Re: Section 73 application to vary Conditions 1 and 4 of Prior Approval DC/2019/00890 at Linacre House, Stanley Road, Bootle L20 3AQ

DLP Planning Ltd have been instructed by our client, Featherfoot Linacre Limited to submit an application under Section 73 of the Town and Country Planning Act 1990 to vary Conditions 1 and 4 of Prior Approval DC/2019/00890.

TITLE
PROPOSED SITE PLAN

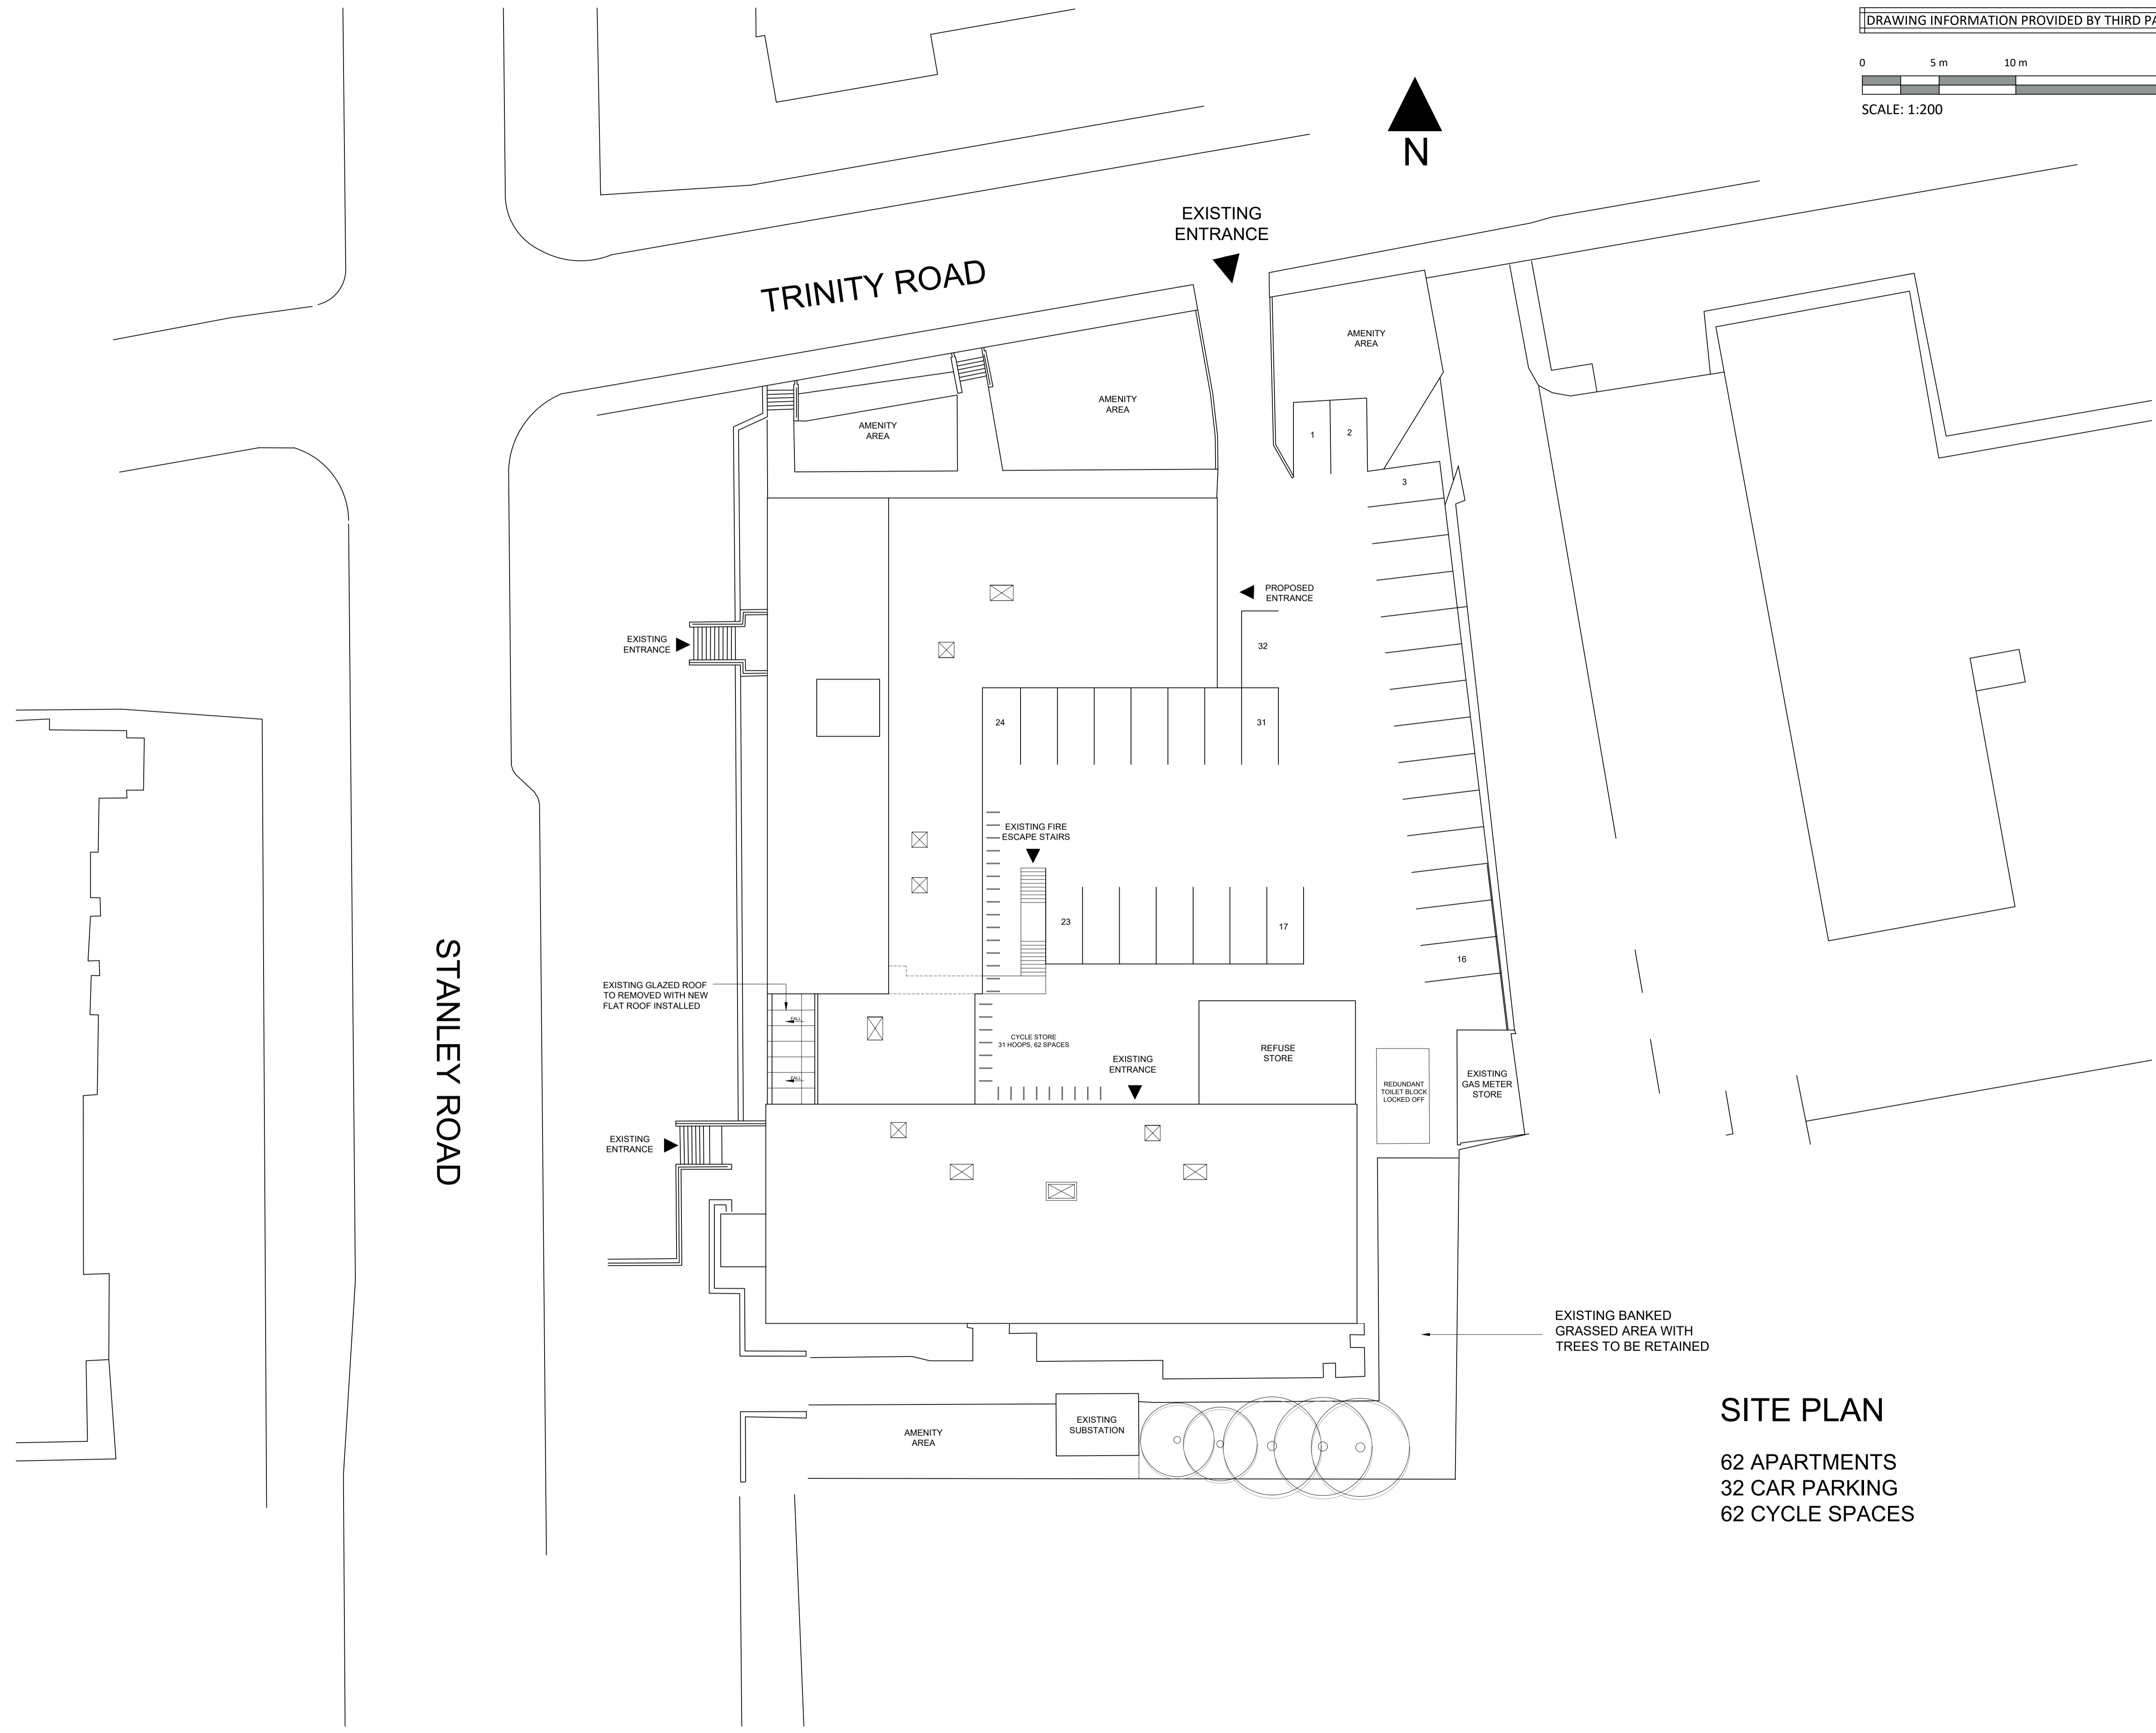
The Proposed Site Layout Plan (K899/01 Rev C), approved as part of the original prior approval, showed the cycle parking provision located within the south west corner of the site. Provision of the cycle parking at this location would have resulted in a reduction in the existing landscaped area, potential loss of trees and issues arising from the location of underground utilities associated with

the adjacent sub-station.

Based on the above, the applicant is seeking to regularise the relocation of the cycle parking to within the central parking area through the substitution of the approved Proposed Site Plan (K899/01 Rev C) with a revised Proposed Site Plan (K899/01 Rev F).

As set out above, the applicant is seeking to regularise the relocation of the cycle parking through the substitution of the approved Proposed Site Plan (K899/01 Rev C) with a revised Proposed Site Plan (K899/01 Rev F). On this basis, this Section 73 application seeks the proposed new wording of Condition 4 as follows:

The development shall not be occupied until facilities for the secure storage of cycles have been provided in accordance with details shown on drawing number PL K899/01 Rev F and they shall be retained in perpetuity thereafter.
